24 November 2020

MP05_0038-MOD-1, RURAL RESIDENTIAL SUBDIVISION – MODIFICATION 1, LOT: 542 DP: 1113791, LOT: 156 DP: 753202 AND LOT: 53 DP: 836998, THE BUCKETTS WAY, TINONEE

TfNSW Response & Requirements

Figure 4 - Proposed lot layout (with staging plan)

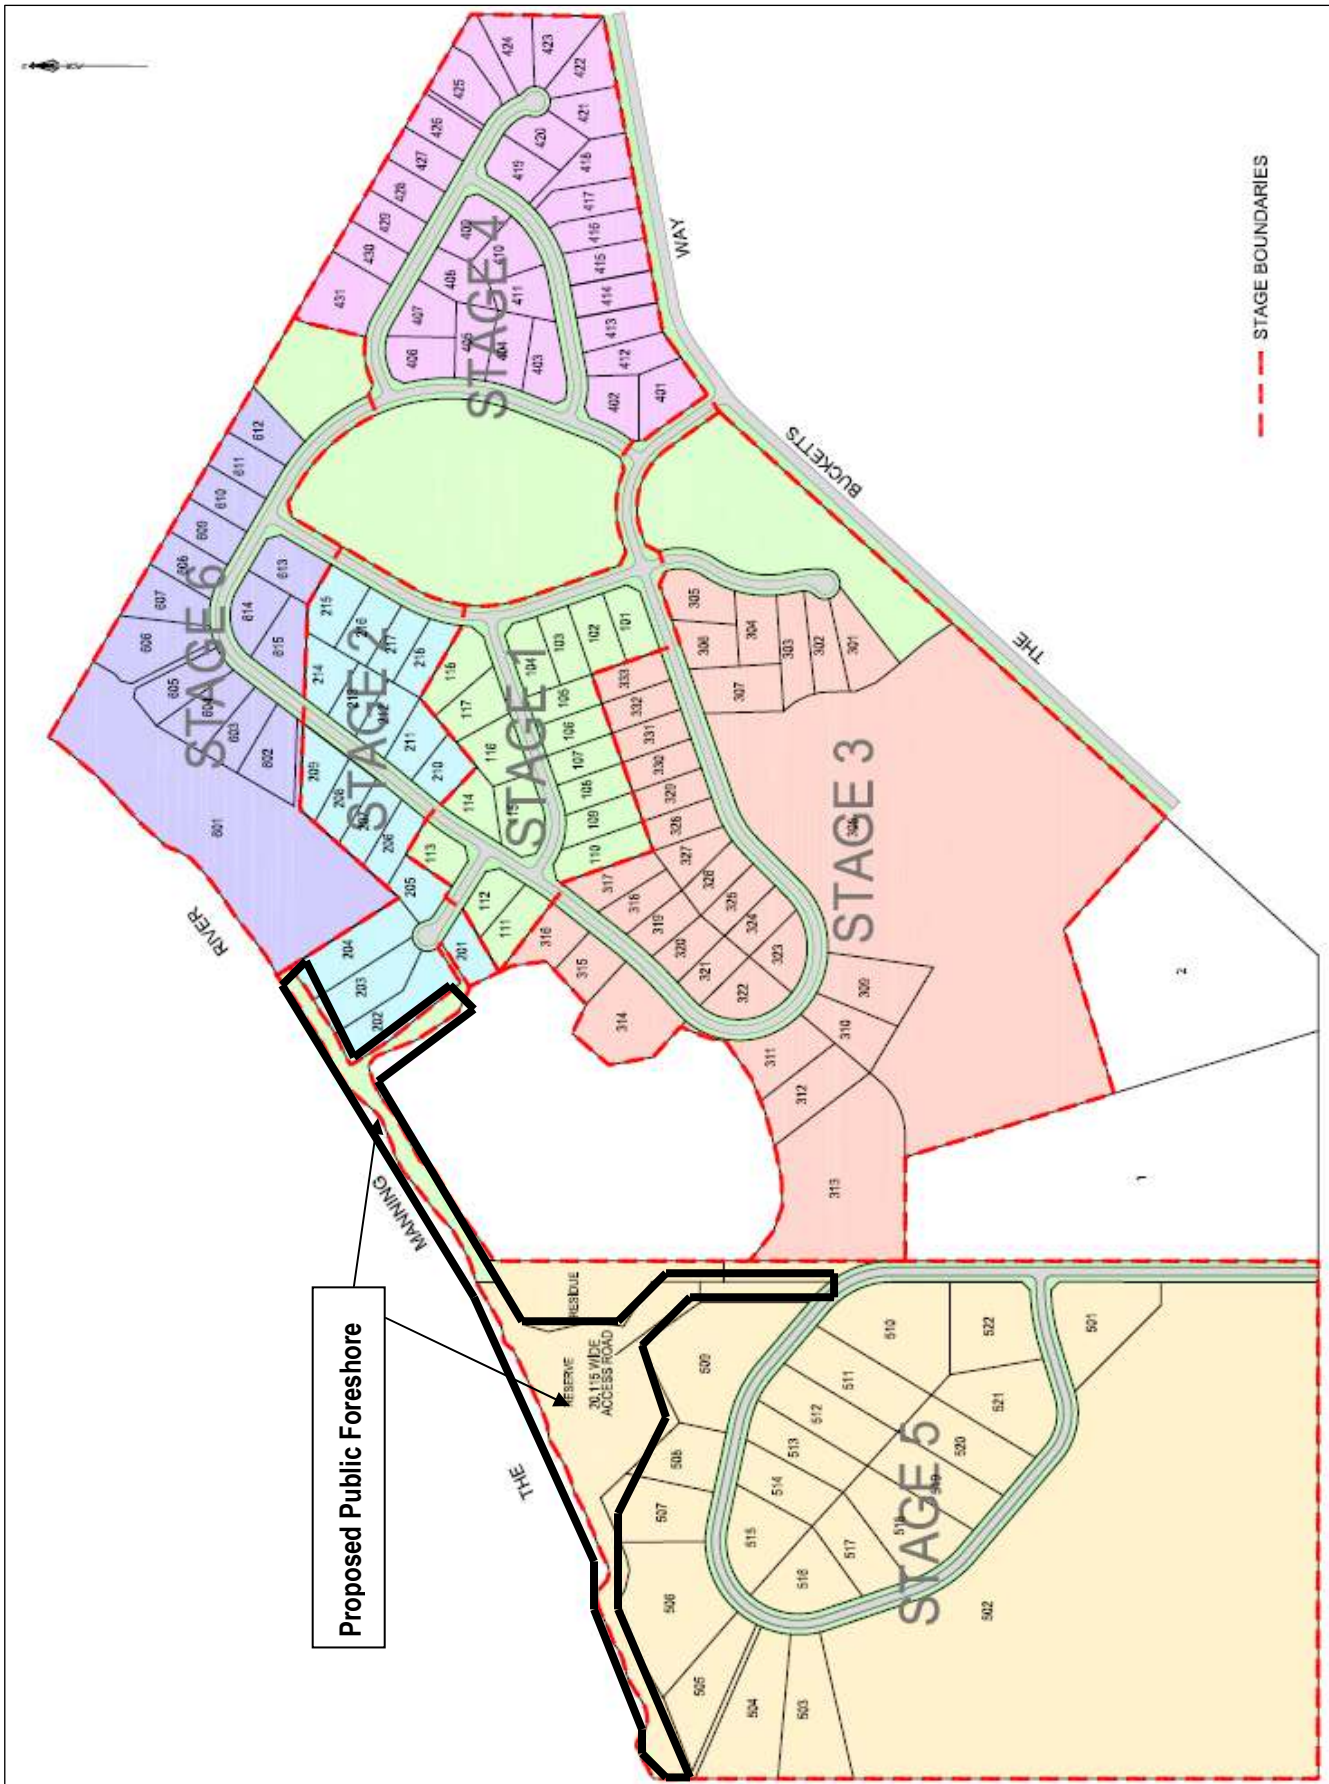
- The proposed modification report however appears to nominate an Auxiliary Right-Turn (AUR) intersection treatment noting the minor reduction in the number of proposed lots. TfNSW highlights that RMS Supplement to Austroads Guide to Road Design Part 4A (RMS17.336, Version 2.1, dated 31 August 2017) does not permit the use of an AUR treatment in NSW.

It is recommended that Council determines the required intersection treatments in accordance with *Austroads Guide to Traffic Management Part 6: Intersections, Interchanges and Crossings (2020)*.
